CITY OF ALBUQUERQUE

May 13, 2022

Re: Champion Xpress Car Wash
9640 Universe Blvd NW
Traffic Circulation Layout
Engineer's Stamp 05-05-2022 (B10-D003J)

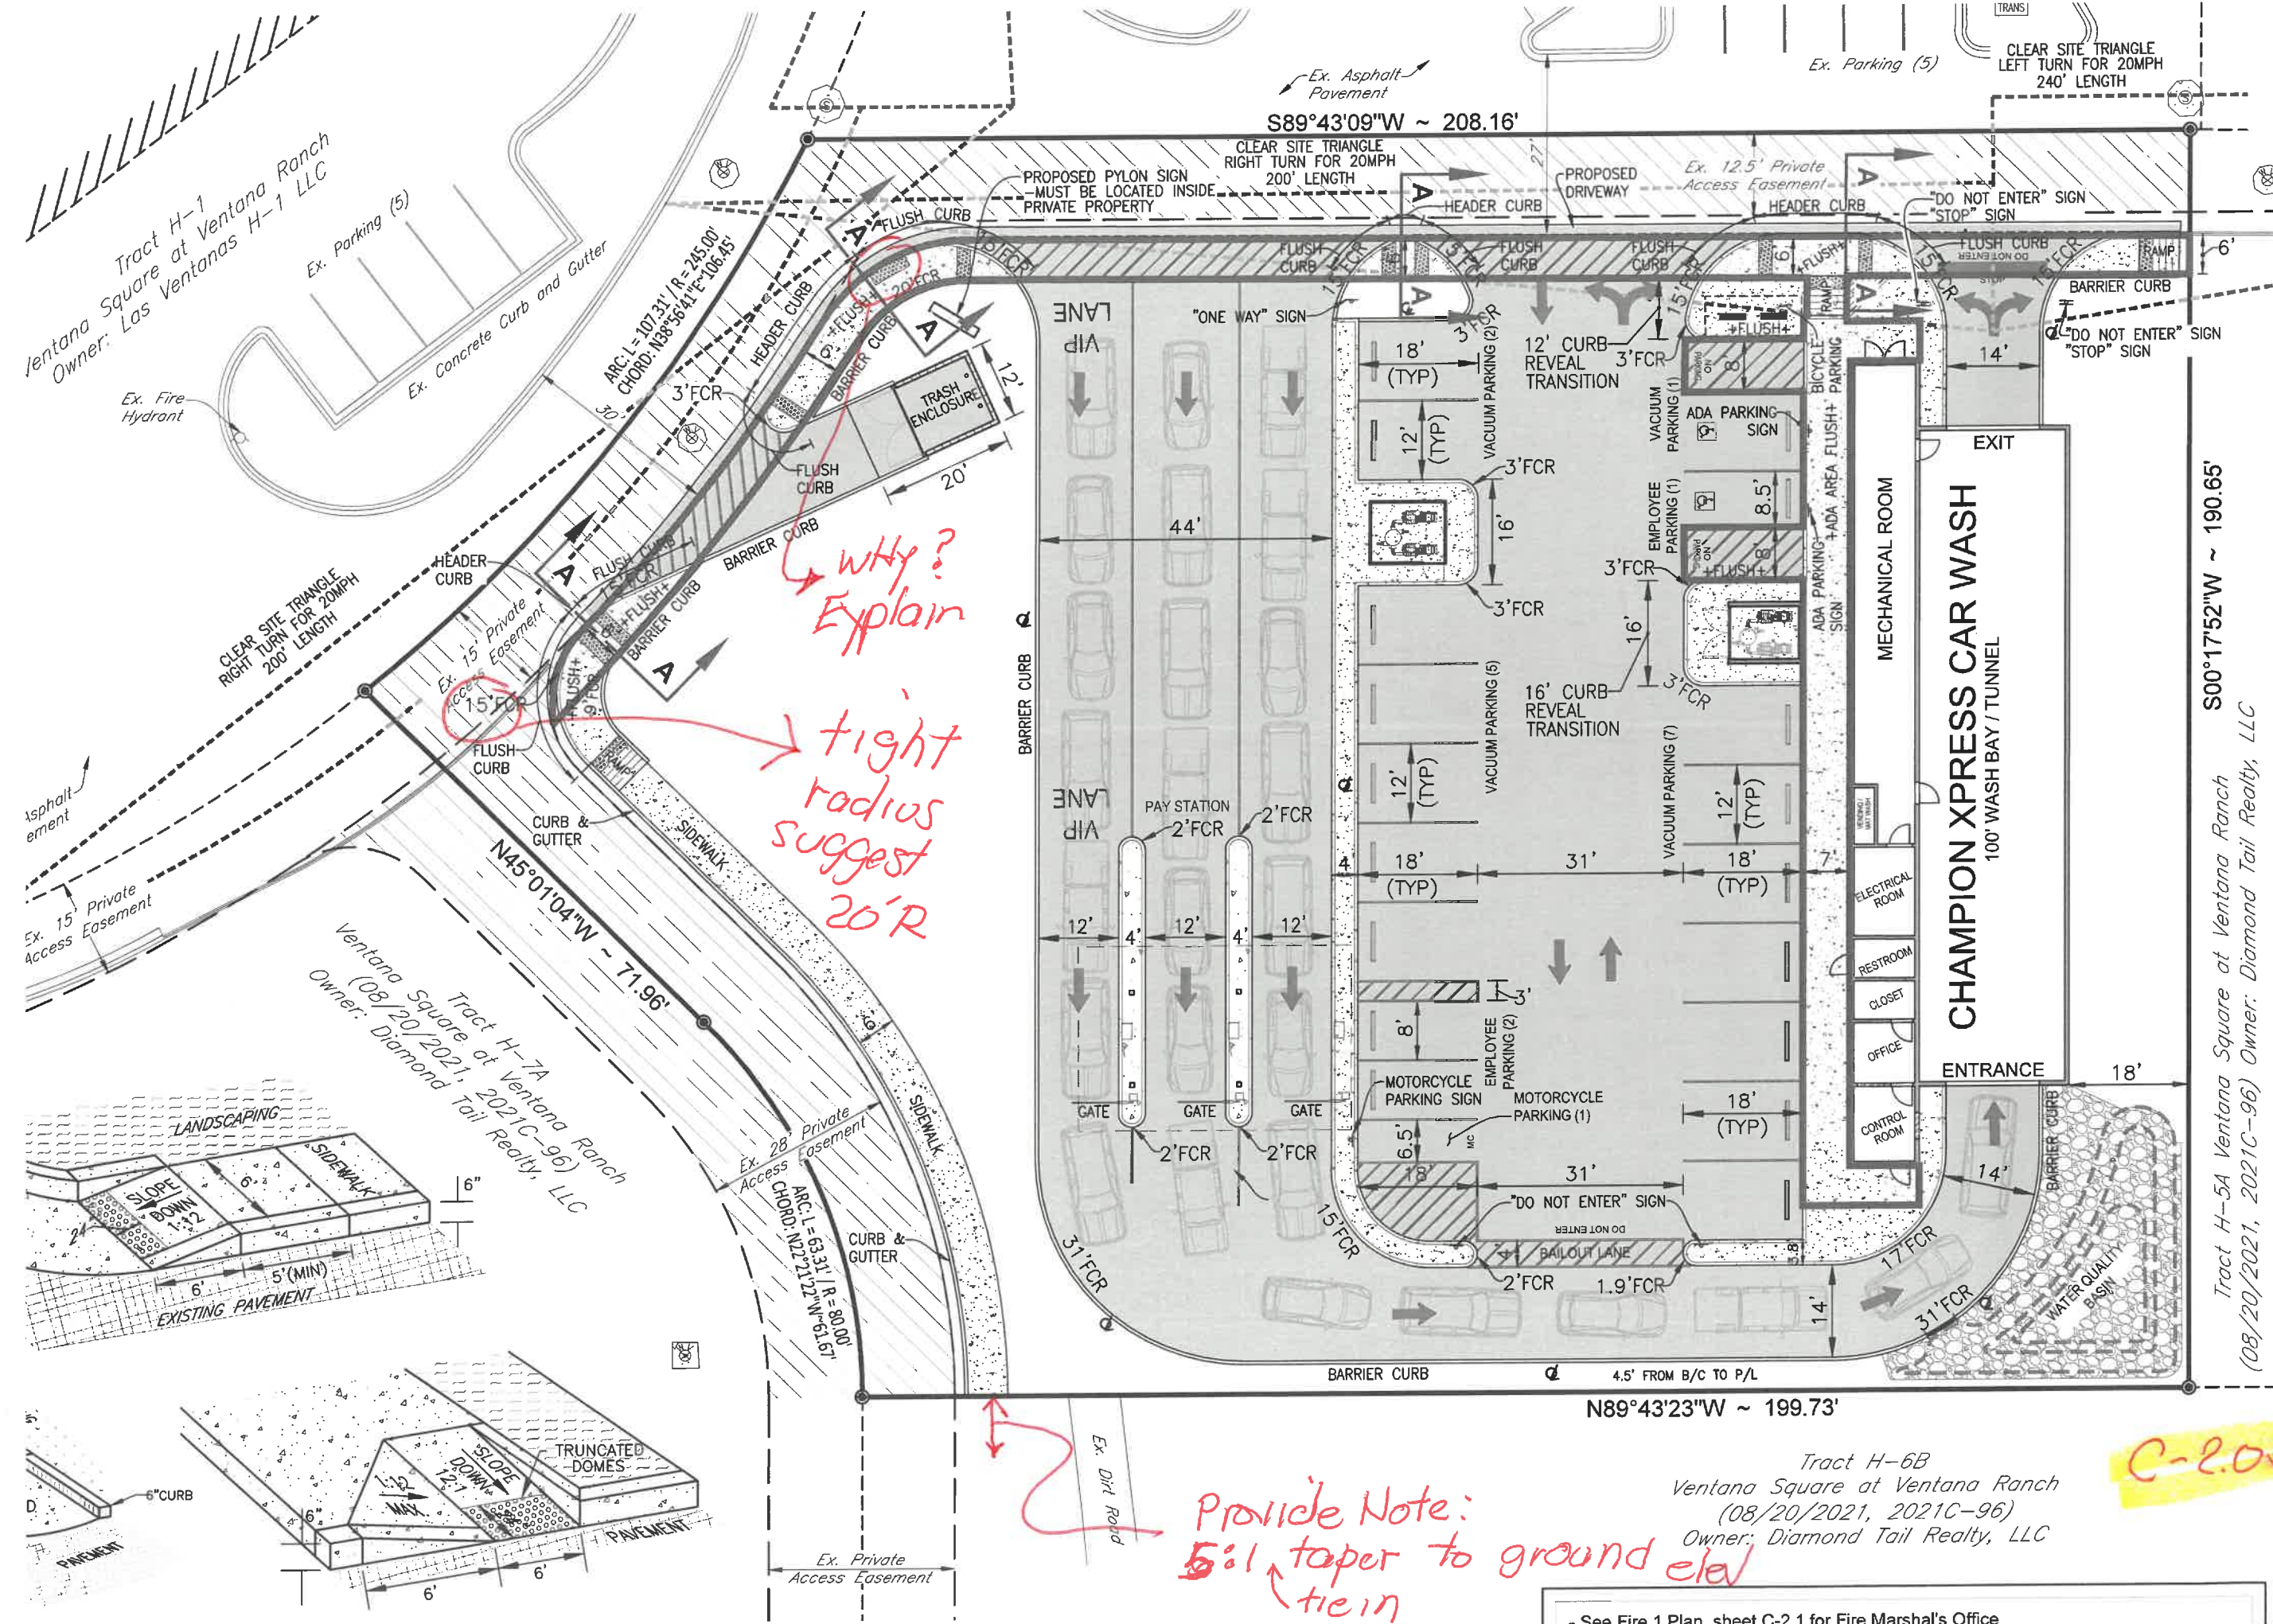
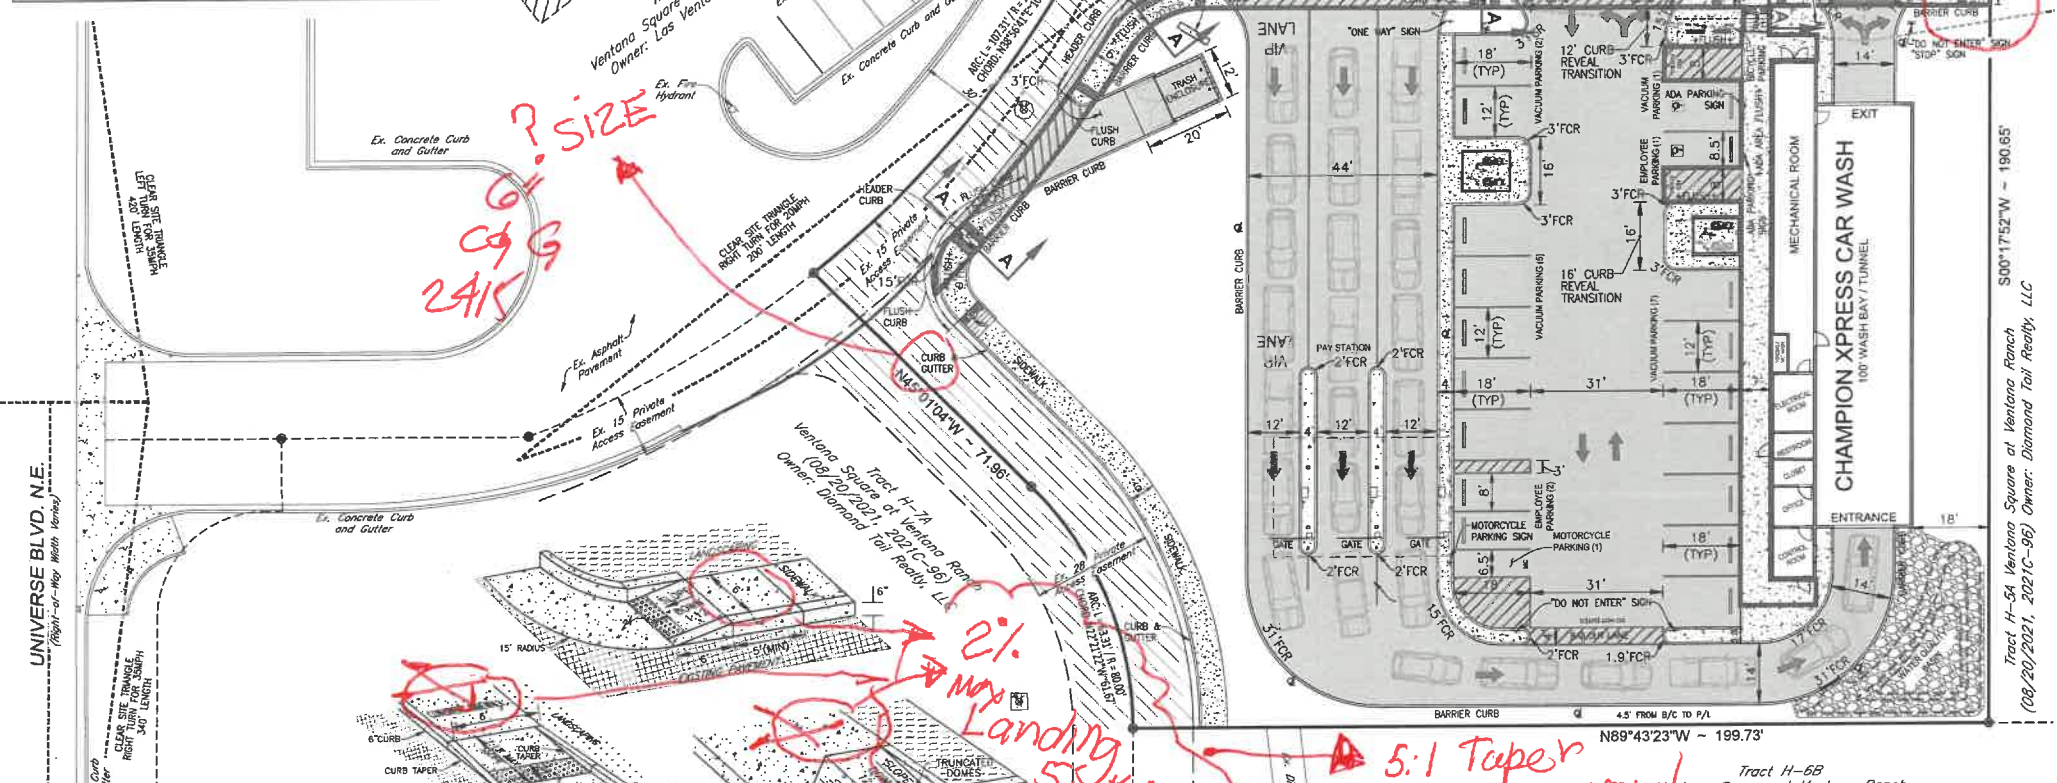
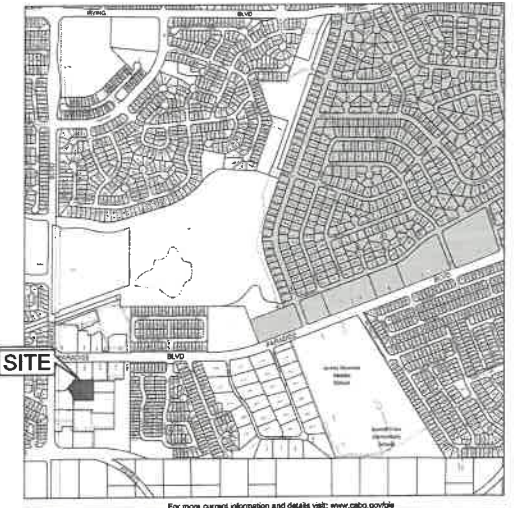
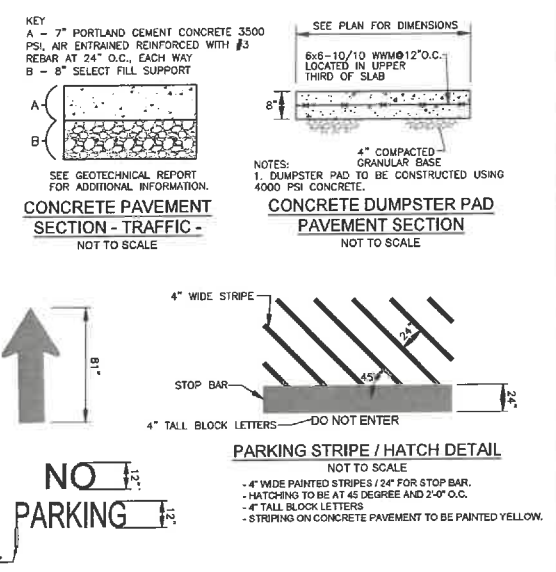
1. Call out COA std dwg 2430 for he proposed Sidewalk at the West of the site.
2. Please see attached and provide a curb when it shows blue. Remove the curb when it shows yellow at the North West of the site. For pedestrian safety issue.
3. Refuse vehicle maneuvering shall be contained on-site. The refuse vehicle shall not back into the public right of way. provide a copy of refuse approval.
4. Provide a copy of Fire Marshal Approval.
5. A copy of receipt for Resubmittal fees paid will need to be provided.
6. Please provide a letter of response for all comments given.
